Thankyou for the consultation. The comments of the **Arun District Conservation Area Advisory Panel** are as follows:

Application No:	AB/46/22/L
Registered:	26th April 2022
Site Address:	2 Maltravers Street Arundel BN18 9AP
Grid Reference:	501779 107169
Description of Works:	Listed building consent for the change of use of building from residential (C3) to a mixed use of residential and art gallery (Class E).

PROPOSED SIGNS AND LIGHTS
SCALE 1:5

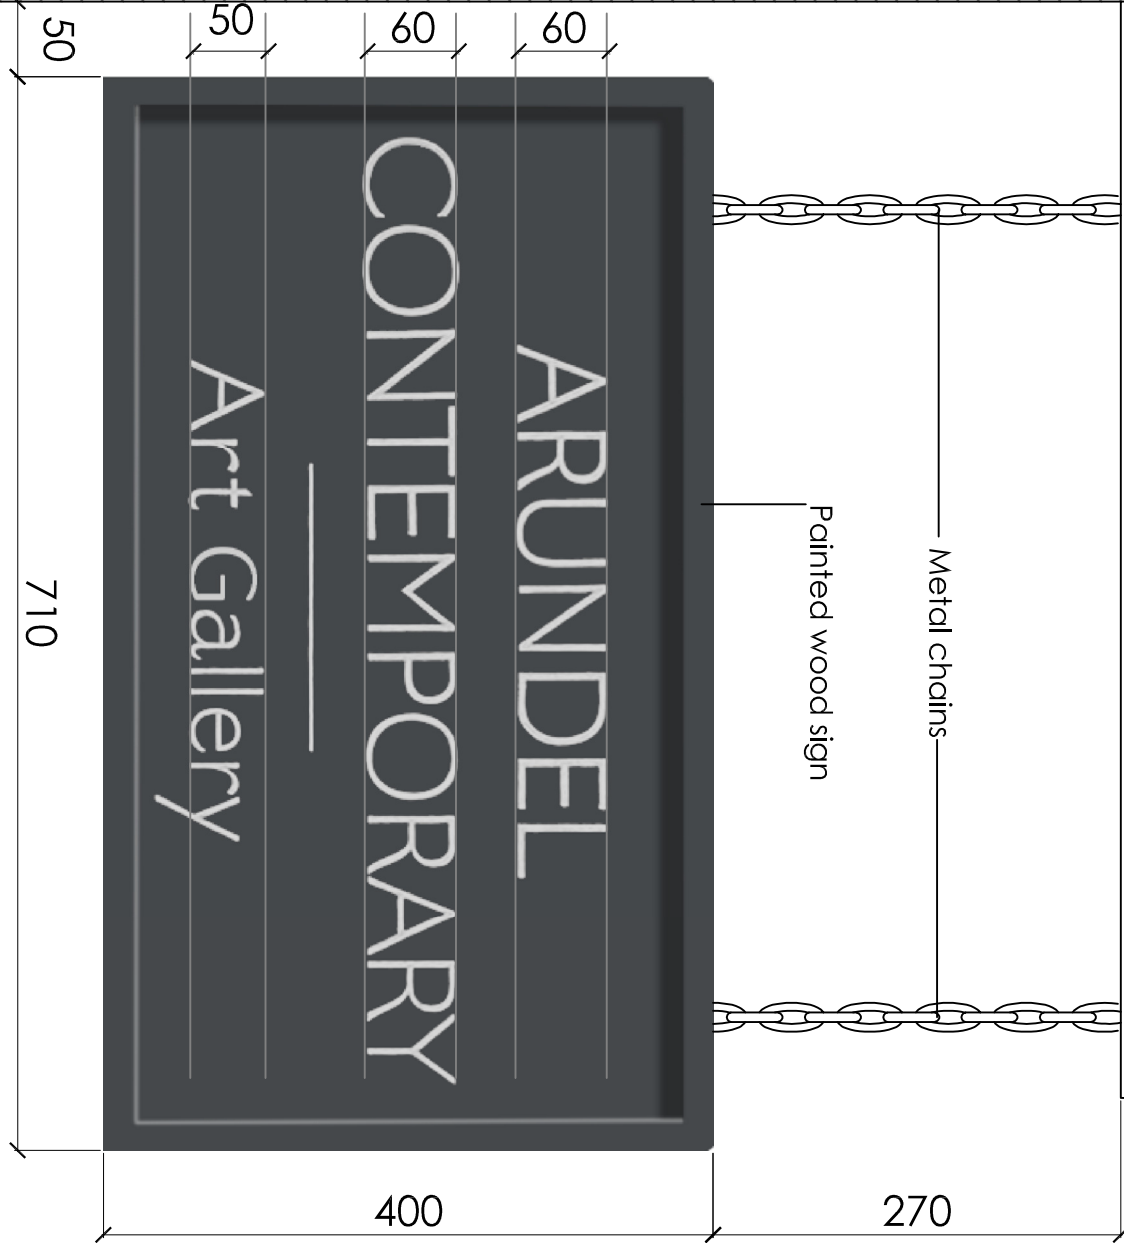
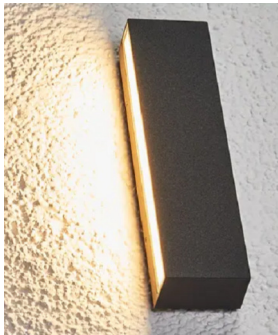
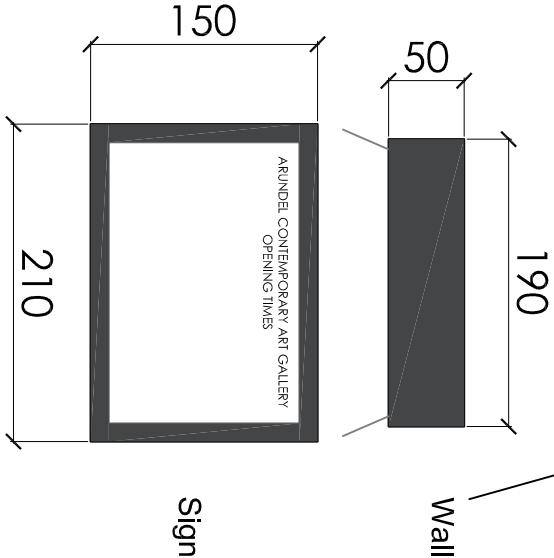
It is the understanding of the Panel that Listed Building Consent is not required for the change in use but is required for any internal or external alterations to the Listed Building. In this instance that would be for the attachment of the information panel, the new hanging sign and for the painting of the front door. If this is correct then surely the description of the application needs changing to specifically mention these particular external alterations.

PROPOSED ELEVATIONS AND SIDE VIEW

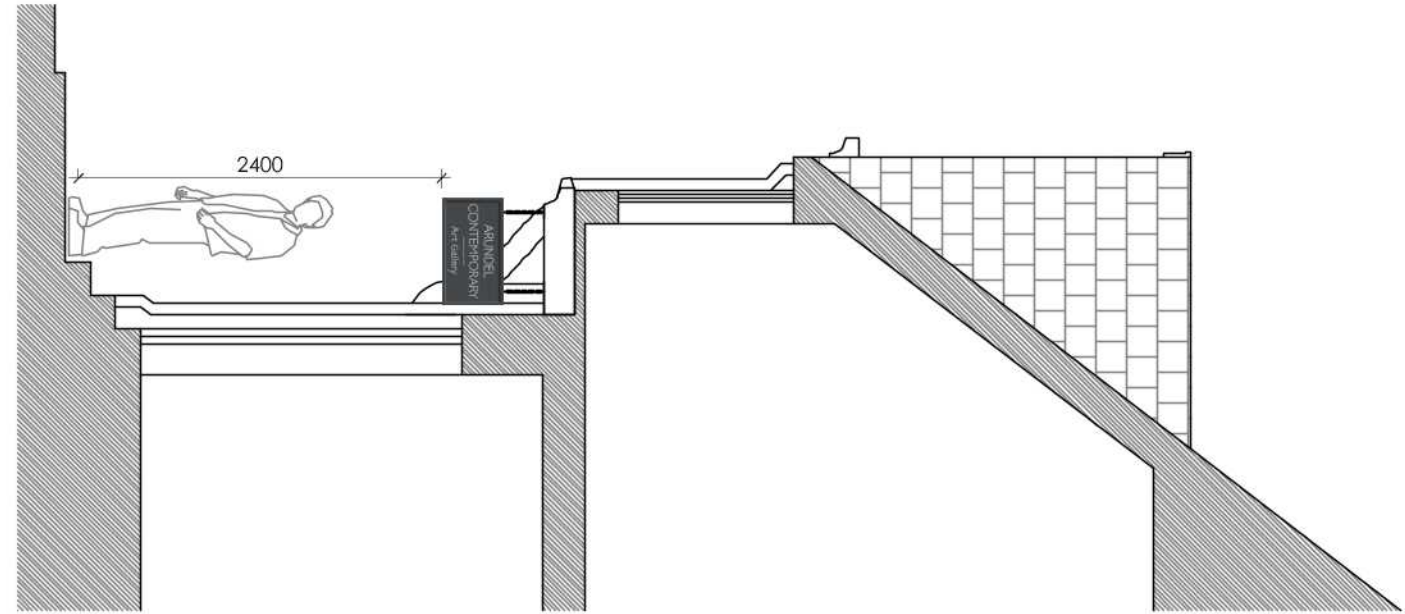
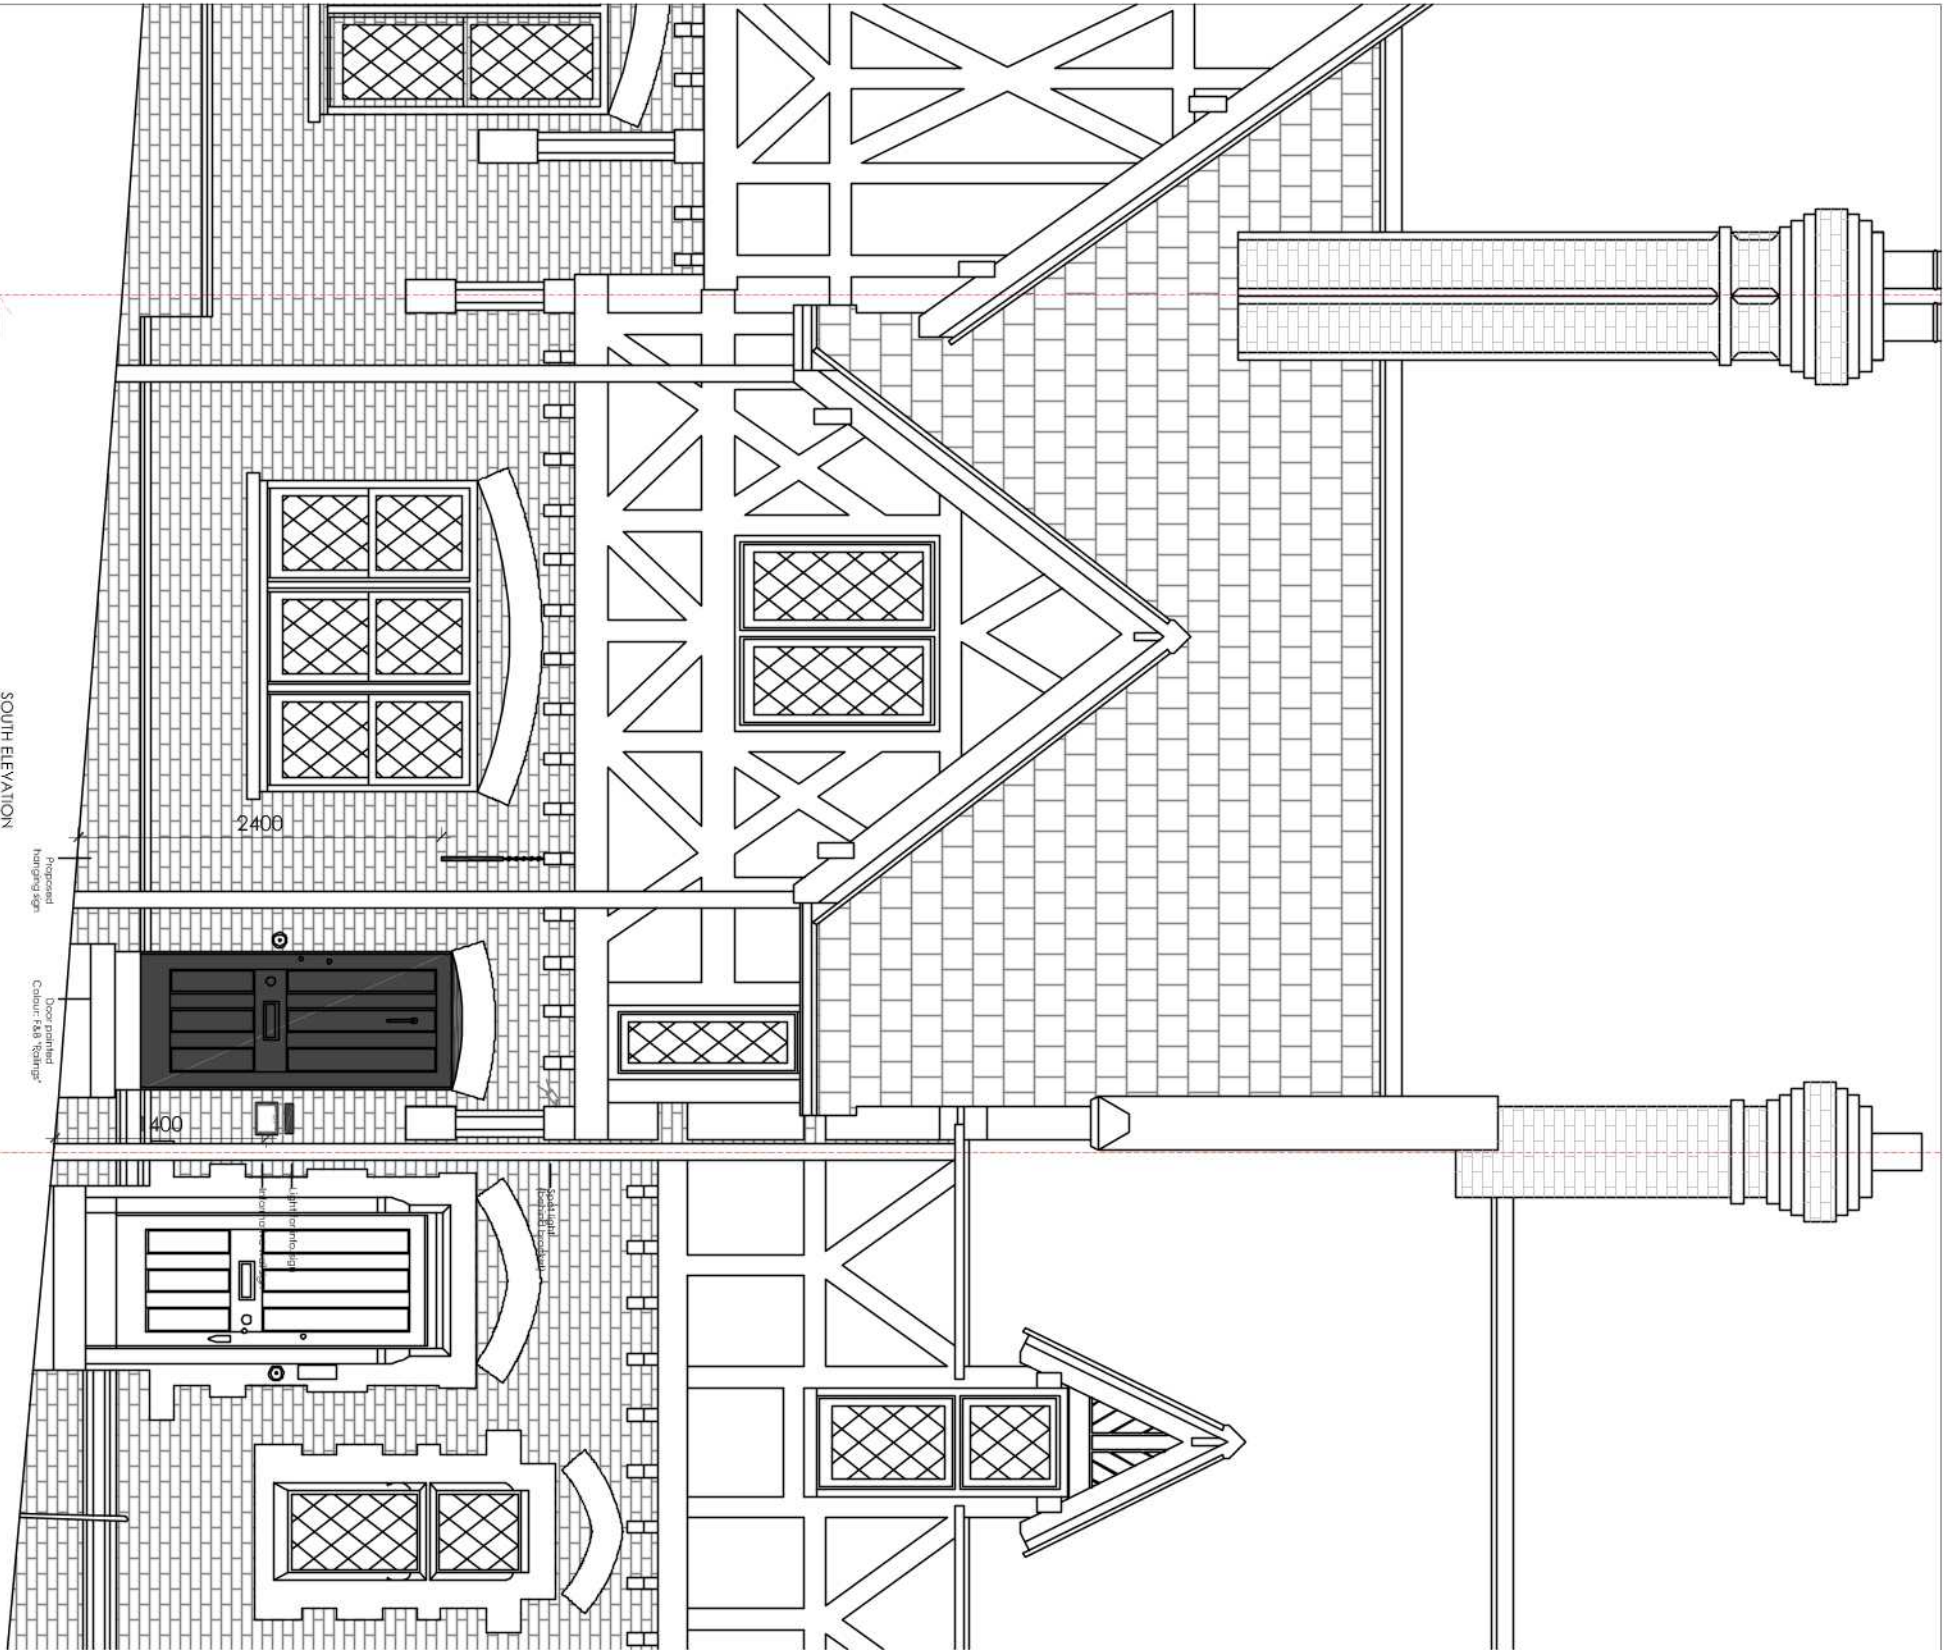
As mentioned in the responses to the planning application and the application for advertisement consent, the Panel have no objections to the change of use or to the proposed advertisements. However, it does object to the painting

of the oak front door which like the other two front doors on the Maltravers Street frontage is of unpainted oak and which is entirely appropriate to the late 19th Century Tudoresque style of the Listed group 2,2a, and 4 Maltravers Street. It should also be noted that the oak doors are mentioned in the listing description of the group.

The Panel consider that the painting of the oak front door will impact adversely on the character and appearance of the listed buildings and also that of the conservation area.
